CITY OF PORTLAND
 FIRE PREVENTION BUREAU
 380 Congress Street, Portland, Maine 04101
 fireprevention@portlandmaine.gov
 (207) 874-8400

NOTICE OF VIOLATION AND ORDER TO CORRECT

Responsible Party 1: Larsson Eric 65 Berkeley Street Portland, ME 04103		
Location 572 BRIGHTON AVE	CBL 185 C013001	Inspection Date 3/29/2017
Inspector John Brennan	Inspection Type Legalize Nonconforming units	Status Failed

# 2ND FLOOR RESIDENTIAL

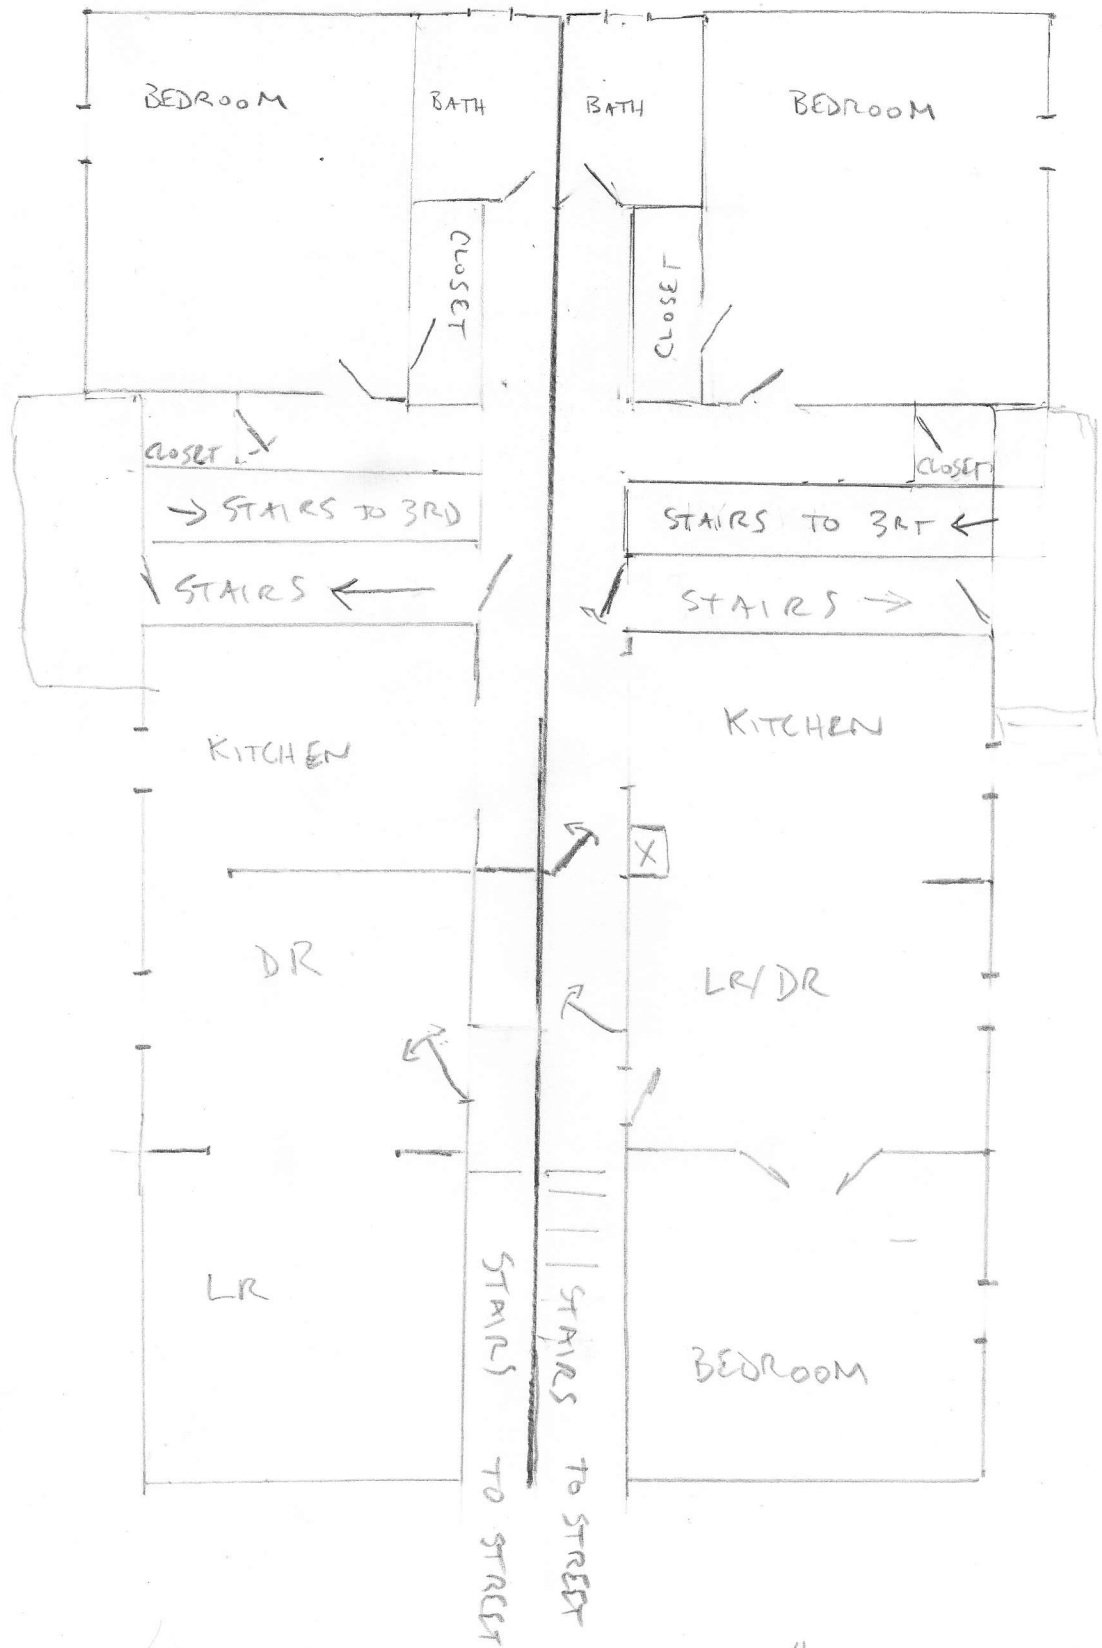
Violation	Proposed Date of Completion
NFPA 70- ARTICLE 110.12 B EXPOSED WIRING CONNECTIONS ; Internal parts of electrical equipment, including busbars, wiring terminals, insulators, and other surfaces, shall not be damaged or contaminated by foreign materials such as paint, plaster, cleaners, abrasives, or corrosive residues. There shall be no damaged parts that may adversely affect safe operation or mechanical strength of the equipment such as parts that are broken; bent; cut; or deteriorated by corrosion, chemical reaction, or overheating. Cover old detector wires and opening with a blank plate in Apartment 2W	___ / ___ / ___
NFPA 101- 8.3.4.2 60 MINUTE FIRE DOOR REQUIRED ; Refer to NFPA 101- Table 8.3.4.2 that states fire door assemblies for vertical shafts (including stairways, exits, and refuse chutes) are rated and required for 1 hour. Install a fire rated door with self-closing hinges for the extra stairwell door for apartment 2W.	___ / ___ / ___
